TfNSW Reference: SYD23/01380/01
DPHI Reference: SSD-58601963

**EXHIBITION OF ENVIRONMENTAL IMPACT STATEMENT (EIS) FOR 96MW DATA CENTRE FACILITY
6 HONEMAN CLOSE, HUNTINGWOOD**

TAB A – TfNSW comments to be addressed as part of the RtS

Figure 5 | Proposed site layout

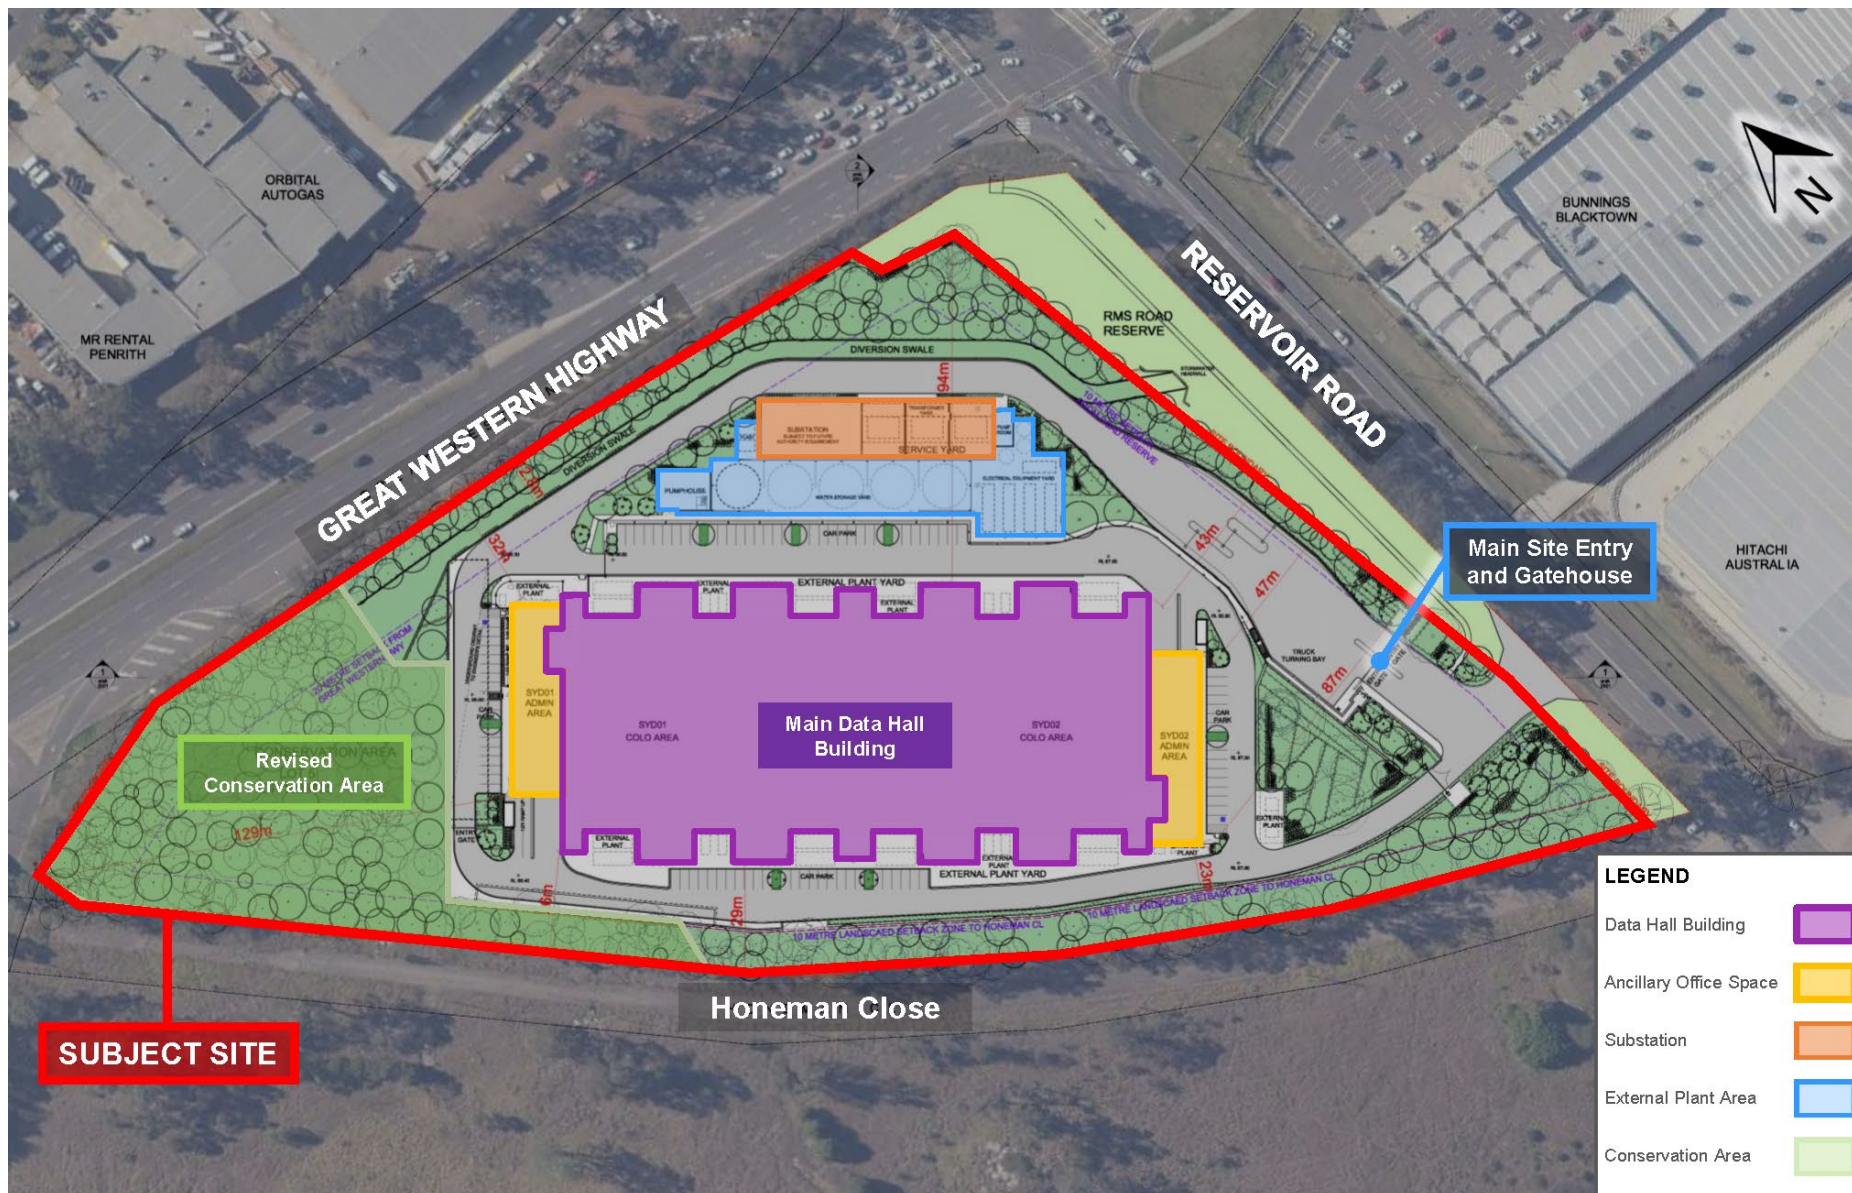
TfNSW has identified that the development proposes access on Reservoir Road, which is a state classified road. As such, separate TfNSW concurrence under section 138 of the *Roads Act, 1993* will be required. However, TfNSW will not support access on Reservoir Road when alternative local road access (via Honeman Close) can be achieved by the development.

TfNSW position is consistent with current practice to limit the number of vehicular conflict points along the arterial road network to maintain network efficiency and road safety, which is reflected in section 6.2.1 of the *Guide to Traffic Generating Developments*, which states ‘access across the boundary with a major road is to be avoided wherever possible’. Additionally, clause 2.119 2(a) of the *State Environmental Planning Policy (Transport and Infrastructure) 2021* states that “The Consent Authority must not grant consent to development on land that has frontage to a classified road unless it is satisfied that:

(a) where practicable, vehicular access to the land is provided by a road other than the classified road”

TfNSW notes that existing approval for DA-17-01780 had vehicle access via Reservoir Road, however, advises that this development proposed a service station with ancillary uses. As the proposed development is not similar in terms of function, operation, TfNSW do not deem it appropriate to have the same vehicular access.

TfNSW requires that the development amends the vehicle access to Honeman Close to align with current practice, which ensures a safe systems approach that is suitable for this type of development.
